Project Name (VA-20-00001)

Brown Setback Variance

Parcel 917135

To: Kelly Bacon, Staff Planner

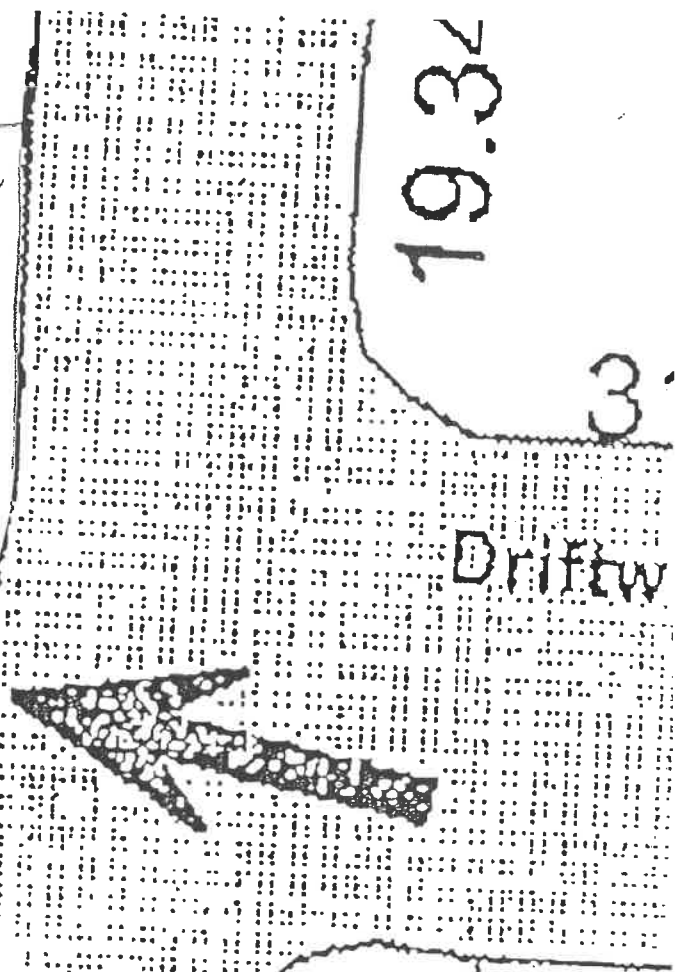
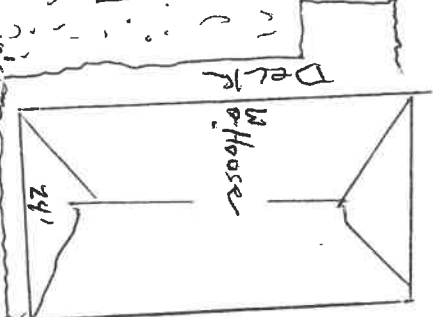
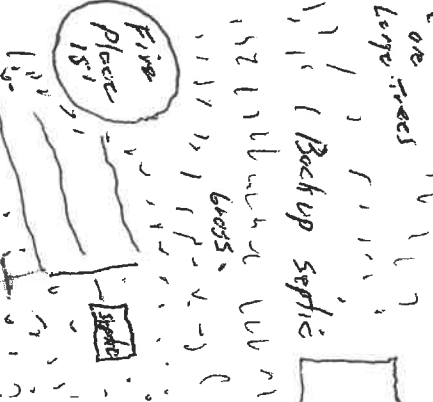
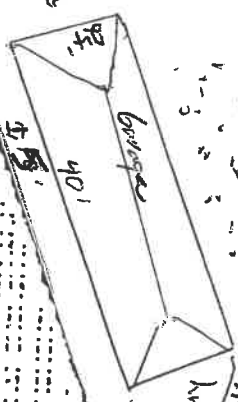
Five feet, instead of 25 feet, is just too close to the road; especially with the 40 foot long garage shown on the site plan. This is a huge garage, especially for such a small lot. While I had difficulty locating a lot size on the county records, it appears to be about .25 acres; much smaller than what seems to be an average area lot size of .50 acres. So, on this much smaller than average lot, which has an 1152 sf house and 144 sf shed (per variance app), the owners are wanting to build a nearly 1000 sf garage, just 5 feet from the street. That seems massive and out of character with the area.

If it does not fit on the front of the house with existing setbacks, they may want to consider putting it on the back of the house. That is on a larger road, with few if any homes that would be impacted as with their current plan.

We do not believe the variance should be granted to reduce the setback by 80% to accommodate this large garage on this very small lot.
